From: Christina Wollman
Sent: Thursday, April 18, 2013 12:04 PM
To: Jeff Watson
Subject: RE: Kittitas County Notice of Application RZ-13-00001 and SP-13-00003
Attachments: FM5300950436B.pdf

I have reviewed this short plat for floodplain regulations. Please add the following condition to the preliminary approval:

**ZENTZ SHORT PLAT**  
**KITTITAS COUNTY SHORT PLAT NO. SP-13-**  
 A PORTION OF THE NW 1/4 OF SECTION 20, TOWNSHIP 18 NORTH, RANGE 18 EAST, W.M.,  
 KITTITAS COUNTY, WASHINGTON

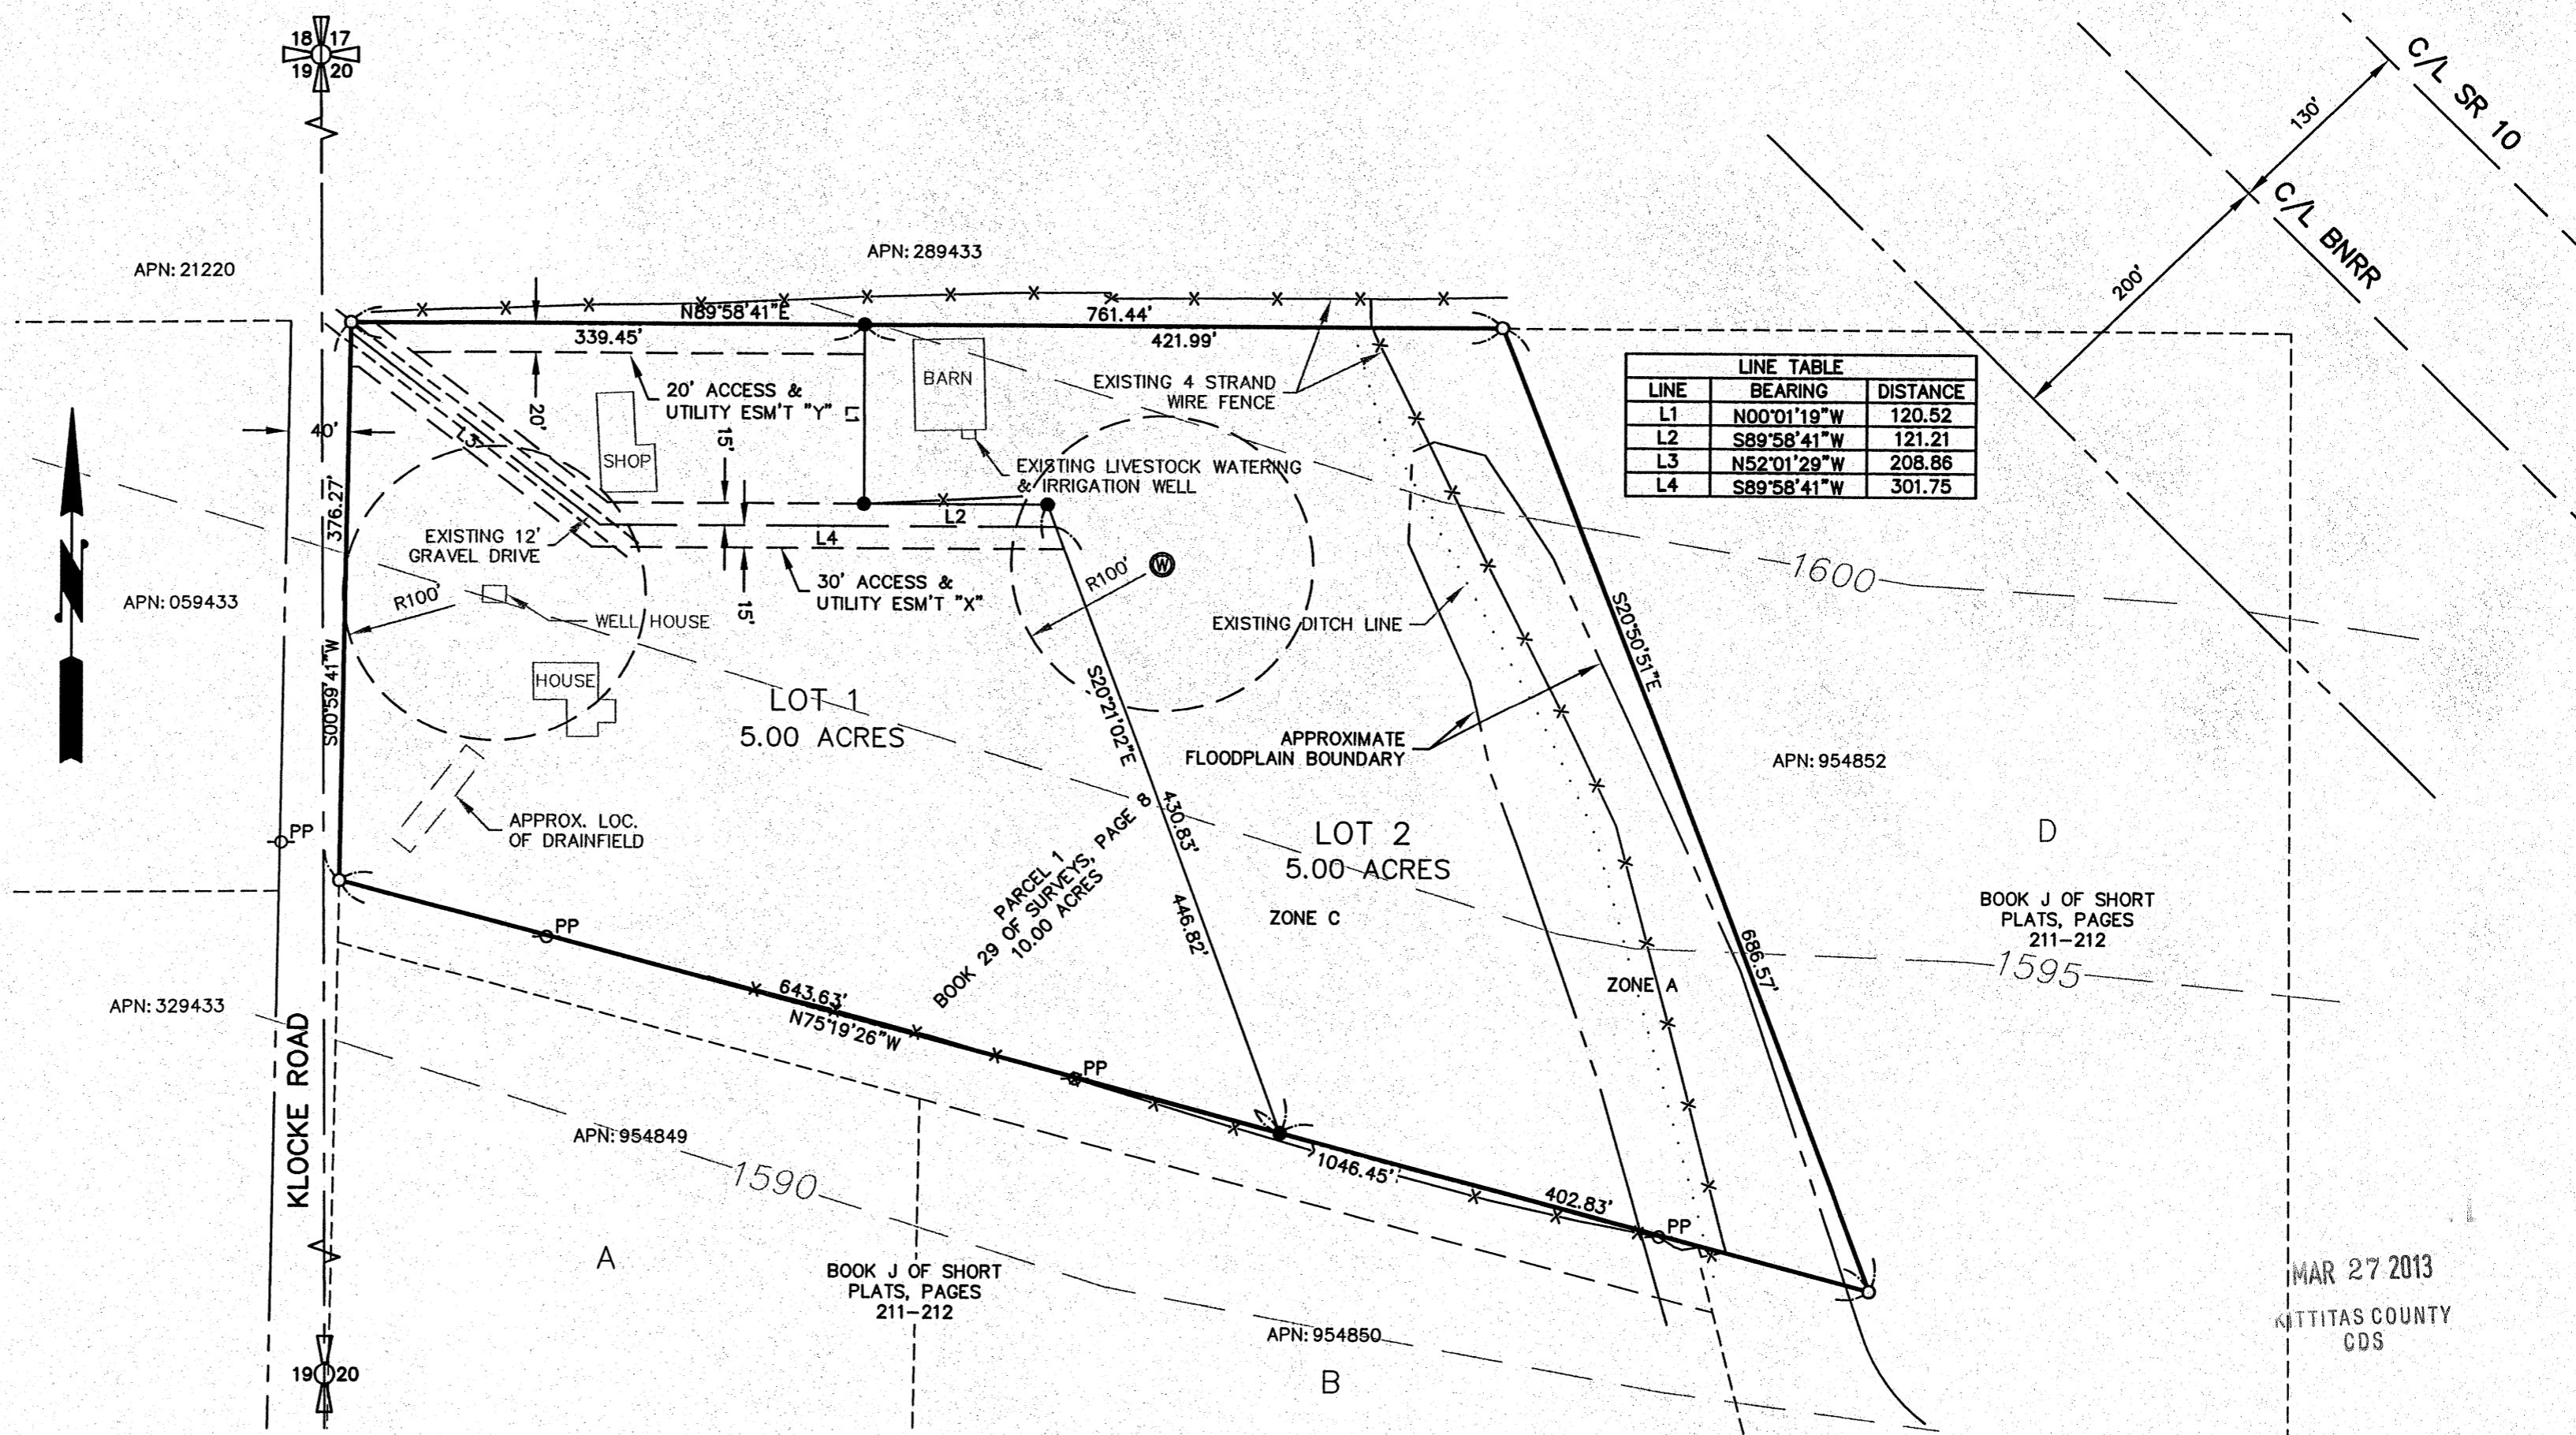
1. If any structures are constructed within the 100-year floodplain, current location at time of development, base flood elevations must be determined for the entire Zone A within the property boundaries as required by KCC 14.08.220(4).
